From: Anita Gardner
Sent: 30 January 2018 16:00
To: Karen Parsons
Subject: FW: A/196/17/DOC - Discharge of Conditions, Angmering Manor

From: Anita Gardner [<mailto:Anita.Gardner@arun.gov.uk>]
Sent: 29 January 2018 09:40
To: 'kestrel.design@lineone.net'
Subject: A/196/17/DOC - Discharge of Conditions, Angmering Manor

CLS/446D
Angmering Manor Soft Landscaping

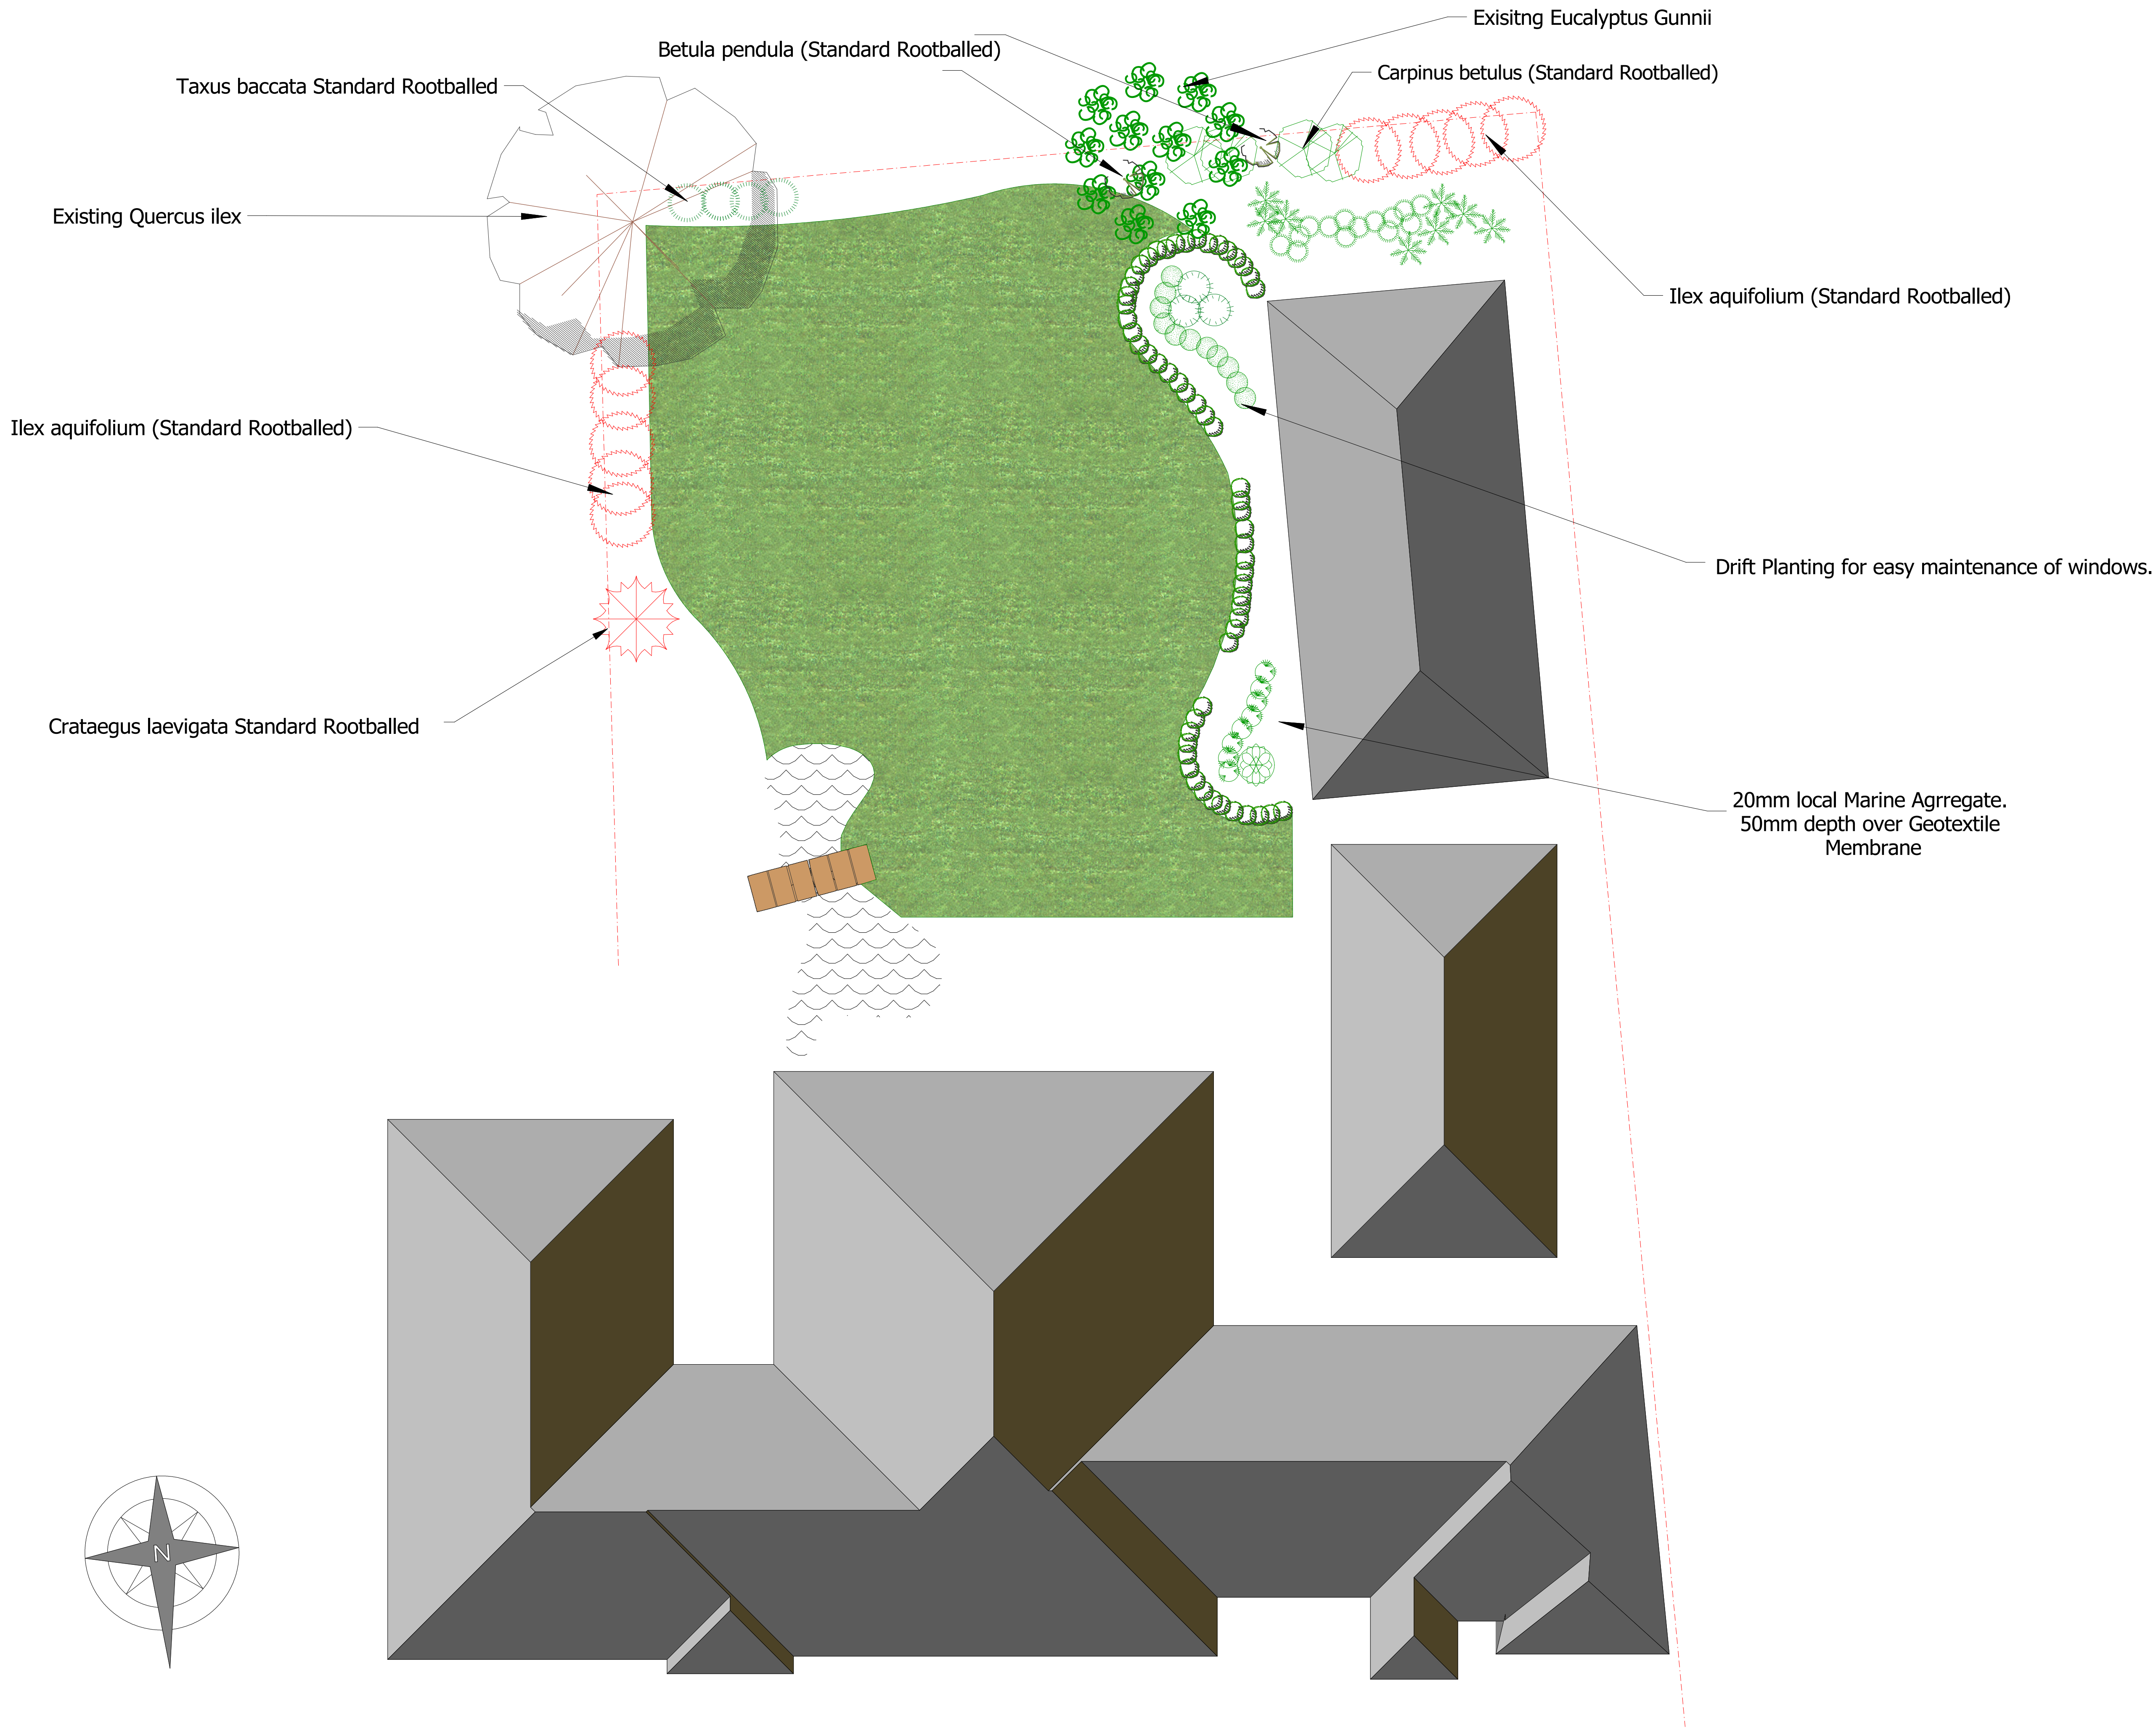
I am awaiting consultation responses on all of the conditions submitted for discharge and am therefore writing to request your agreement to an extension of time on the application until 28-02-2018 to allow for their comments to be received. In the meantime I note that the landscaping plan does not include a reference to the pot size of shrubs, or plant height at time of planting and does not indicate the position of each shrub species on the planting plan. I would appreciate receipt within the 10 days. I would be grateful if the extension of time request could be confirmed by the end of this week.

Regarding the landscaping plan we have requested County Landscapes to amend their plan -- will forward as soon as available.
